October 11, 2013

RE: **Longhorn Steakhouse- Retail Center**

B13-D003A2

Drainage Report and Grading & Drainage Plan for Building Permit

CG-101

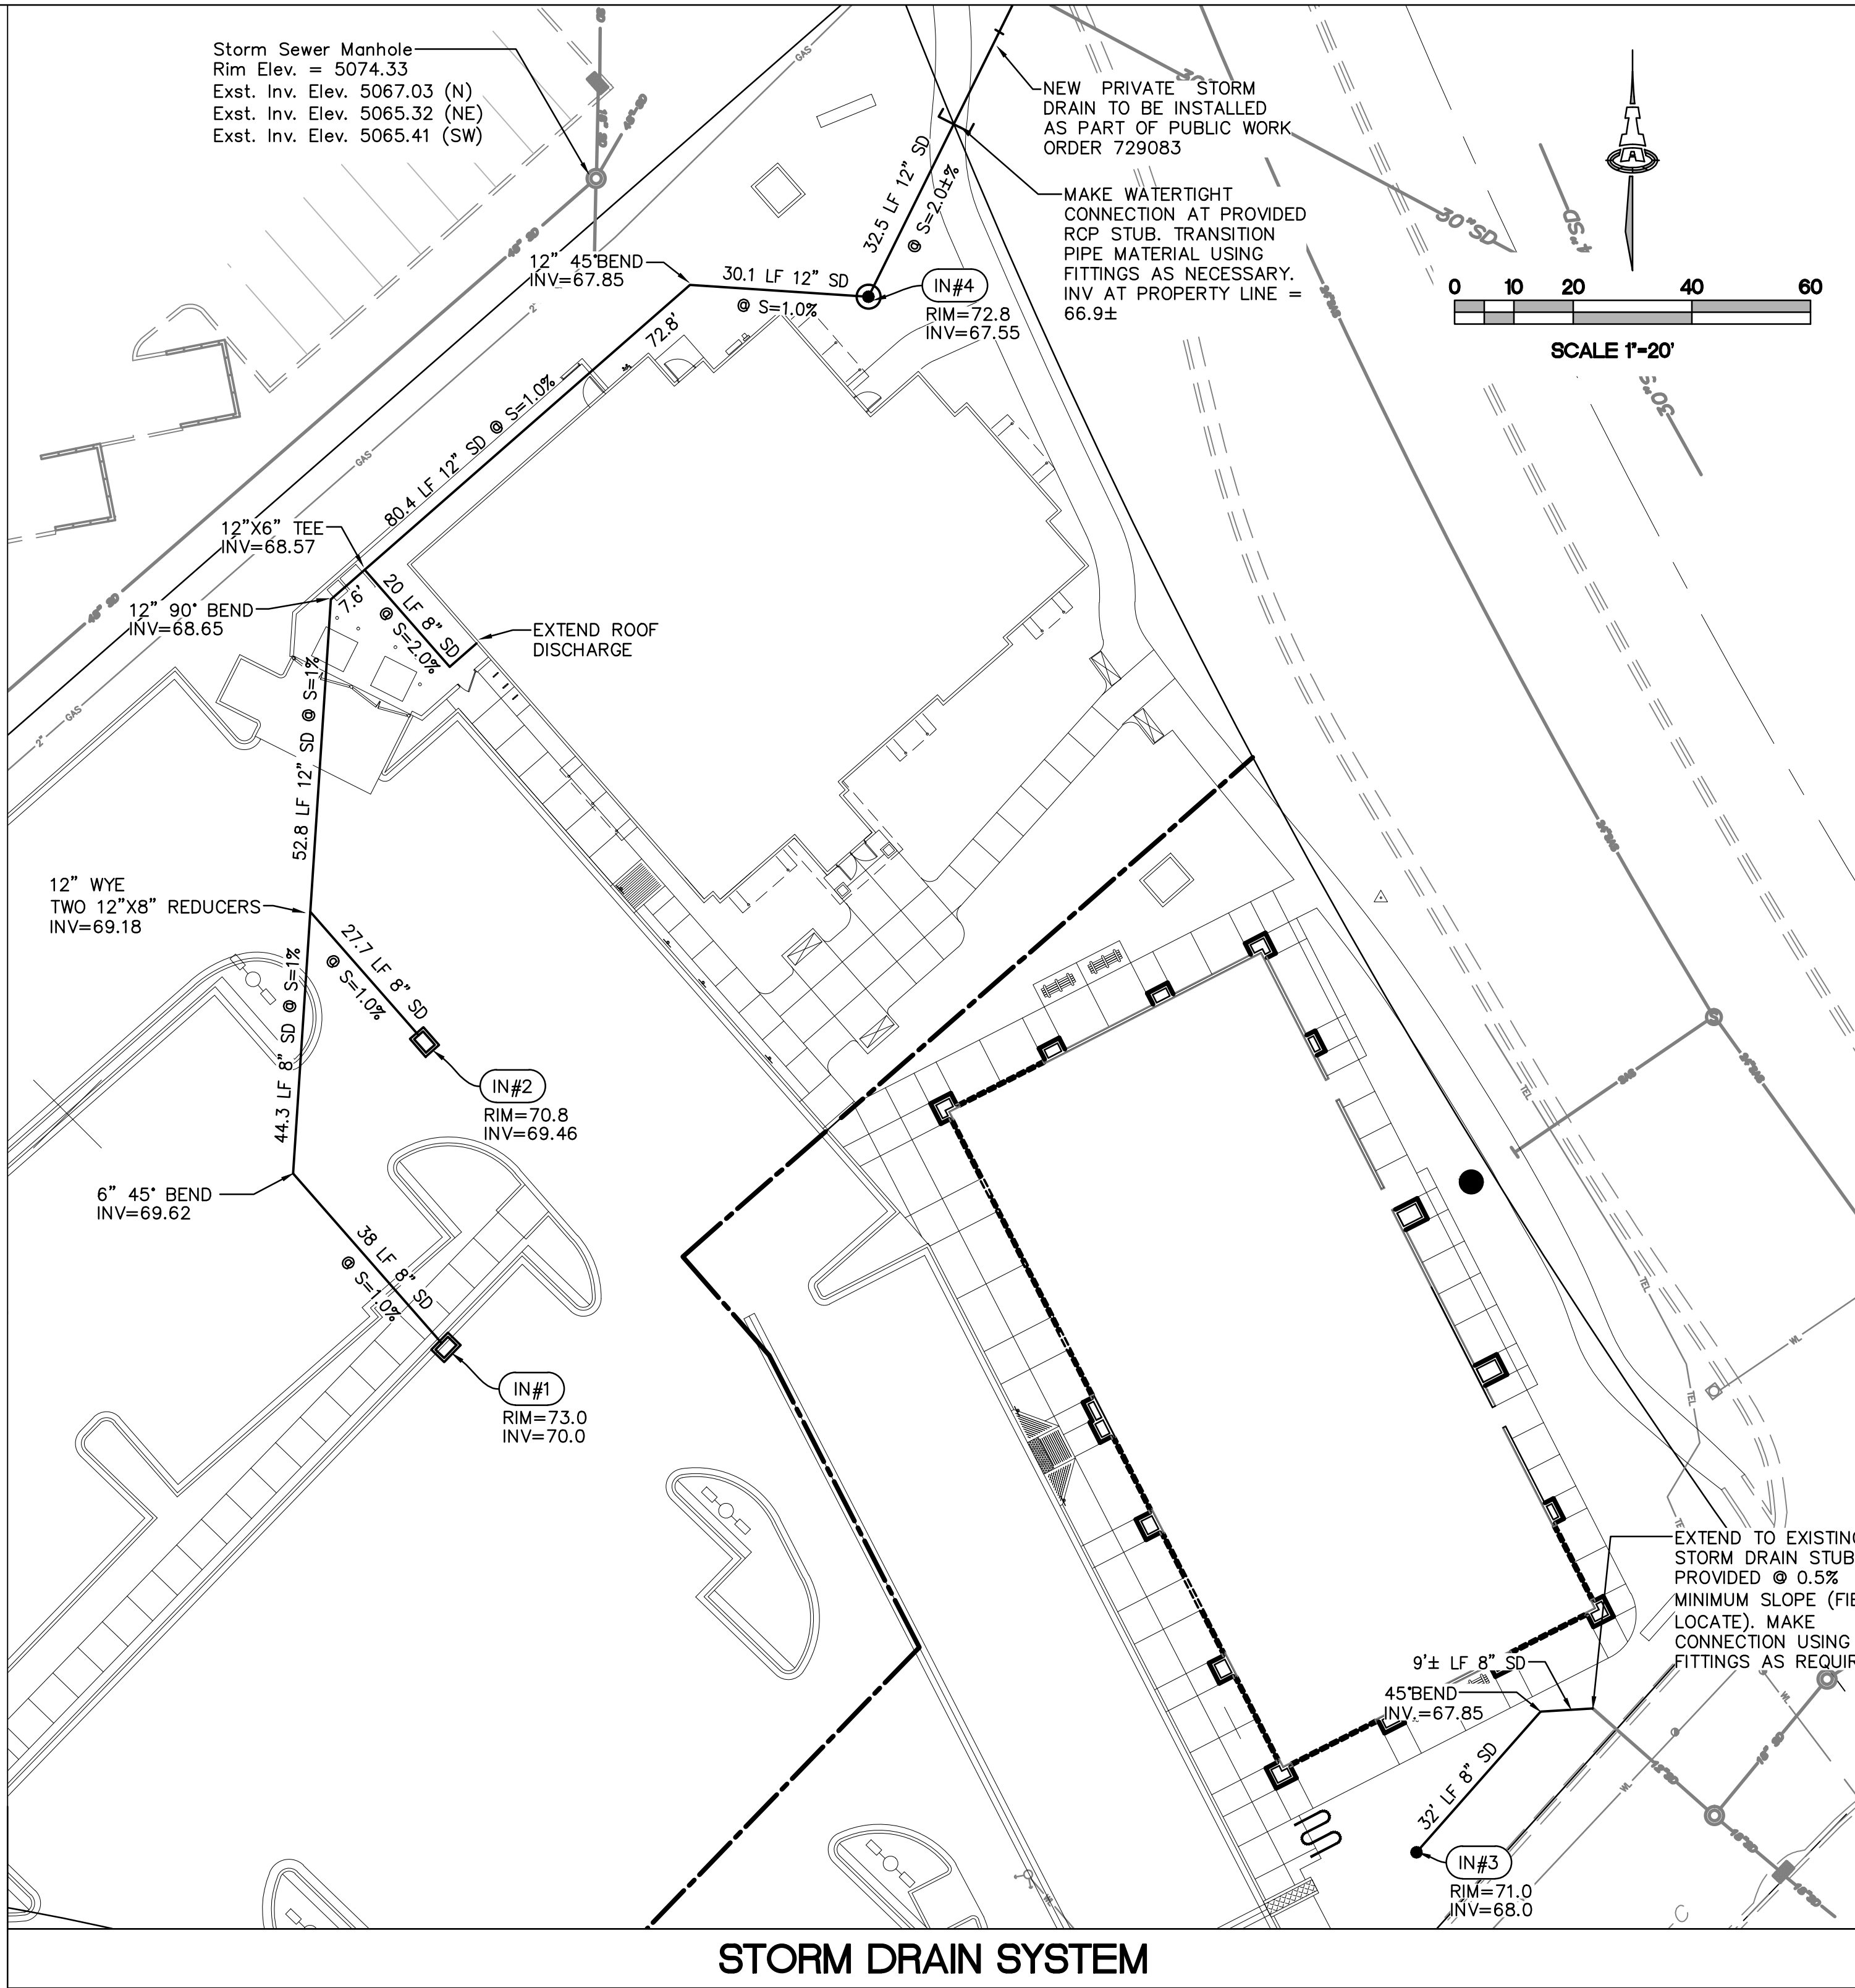
1. *Sheet CG-101, Keyed Note 17: Change "PUBLIC" to "PRIVATE."*
2. *Sheet CG-50: Clarify the build note above the Storm Drain outfall connection to read "**NEW PRIVATE 24" STORM DRAIN TO BE INSTALLED AS PART OF PUBLIC WORK ORDER #729083.**"*
